Application number: 2020/91015	
What is the application for?:	Outline application for erection of 6 apartments (within a Conservation Area)
Address of the site or building:	site adj, 13, Cuckoo Lane, Honley, Holmfirth, HD9 6AS
Postcode:	HD9 5JU

PROPOSED CROSS SECTION

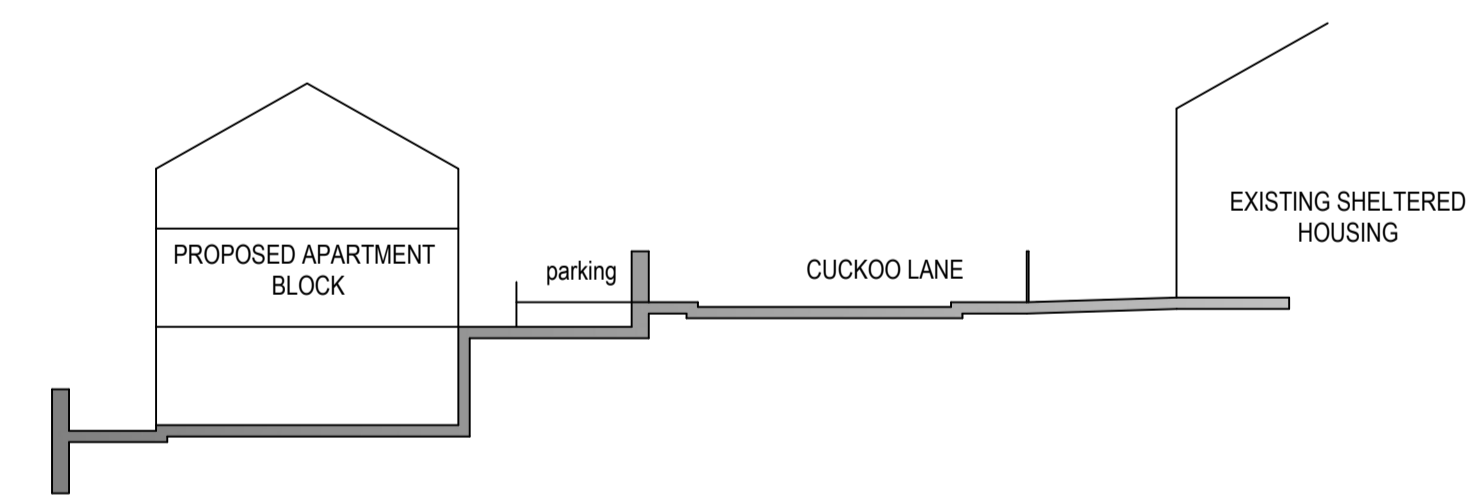
Type of comment: An objection
<p>Planned dwellings will overlook houses on Thirstin Road NOT Moor Bottom and seriously impact on daylight and overlooking these houses, most of which have roof windows. The boundary banking behind said proposal is unstable, previous tree works have already caused minor land slip and damage. Parking issues will lead to parking in already overpopulated streets nearby, residents of the sheltered accommodation opposite have carers and community nurse visitors that will in turn have nowhere to park to reach residents. The narrow street of Cuckoo Lane has no pavement, more traffic to the area will compromise safety of pedestrians, particularly school children getting to and from school. This is a conservation area with a listed building adjacent to the proposed dwellings, a historic wall to the boundary of the listed building and proposed dwellings would be compromised. An overhanging canopy of a 100+ year old tree would need to be disturbed or imbalanced to build the dwellings making it unstable and a danger to the lower properties on Thirstin Road.</p> <p>Kirklees should reject this application.</p>
